**Final Report - Corrections Required**  
**Application No. ANEX-24-0005**

**Description : Matrix Design Group on behalf of Colorado Springs Equities LLC is submitting a serial annexation petition for seven parcels and Land Use Plan/Rezoning exhibit for a portion of the subdivision known as Rock Creek Mesa.**

**Document Filename : Rock Creek Mesa Addition No 4\_Petition\_V3\_5-13-24**

# ANNEXATION PLAT ROCK CREEK MESA ADDITION NO. 4

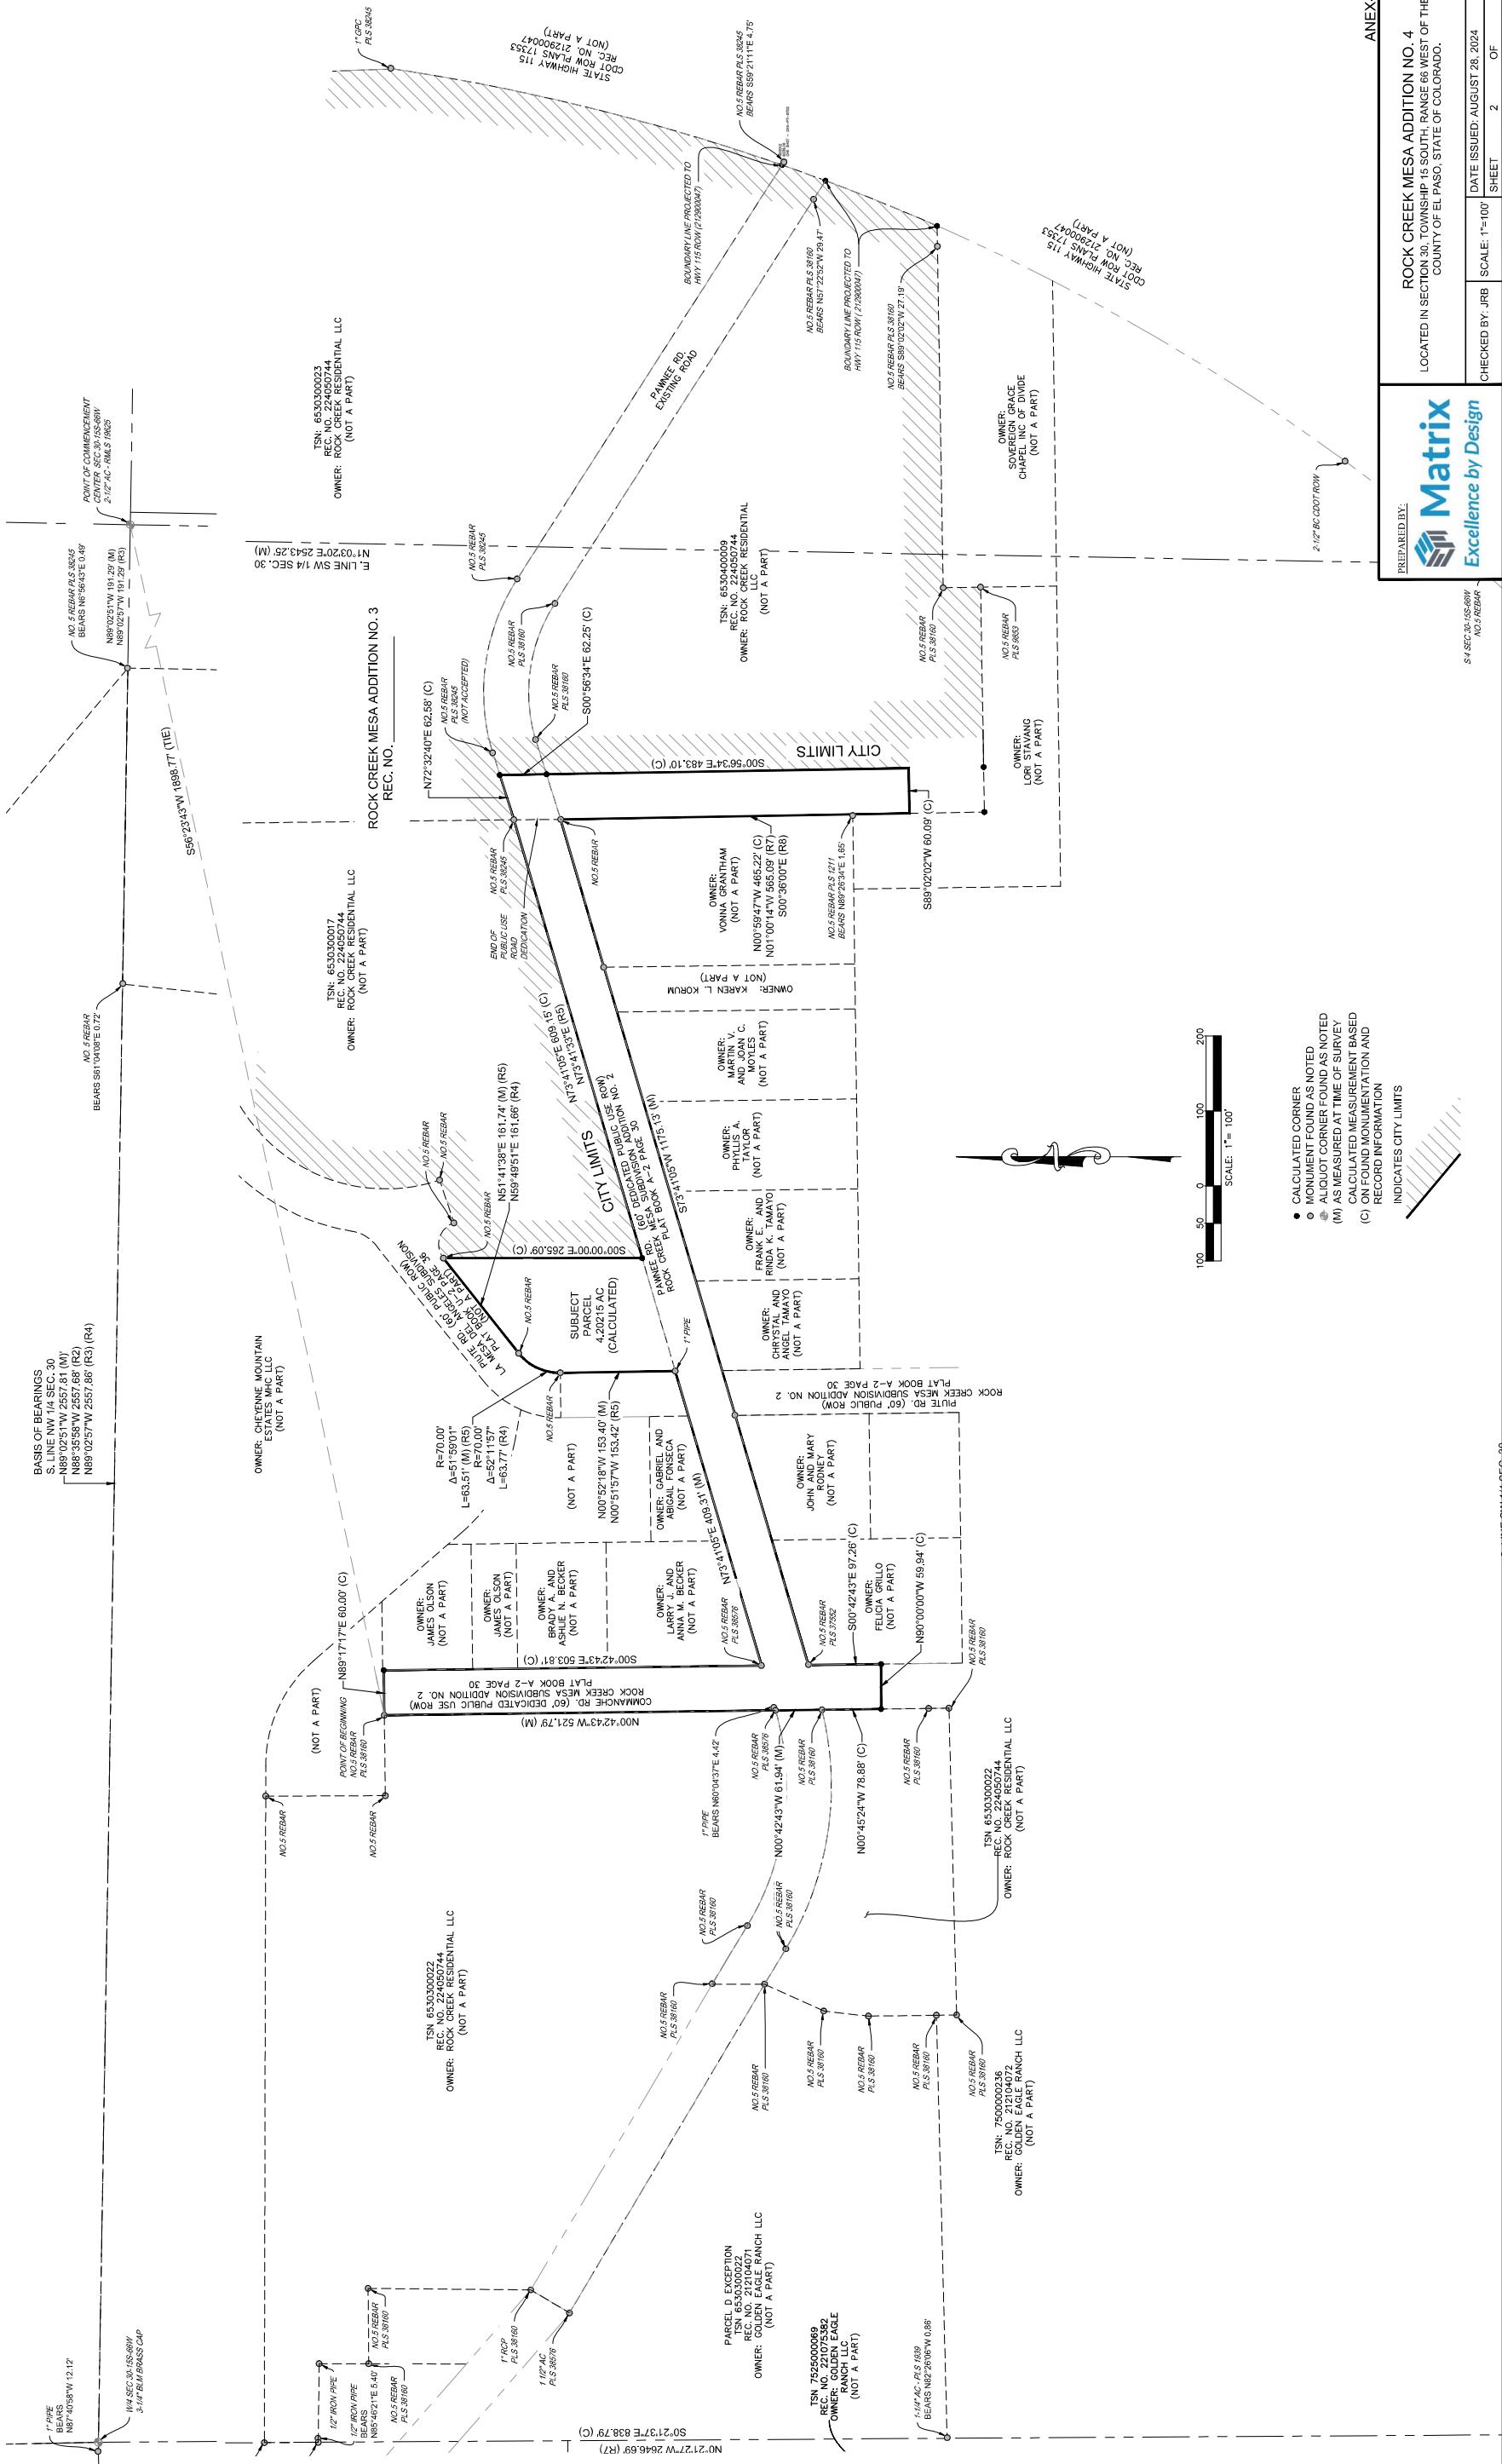
Comment ID	Page Reference	Reviewer : Department	Review Comments
48	1	Gabe Sevigny : Planning	revise legal description accordingly
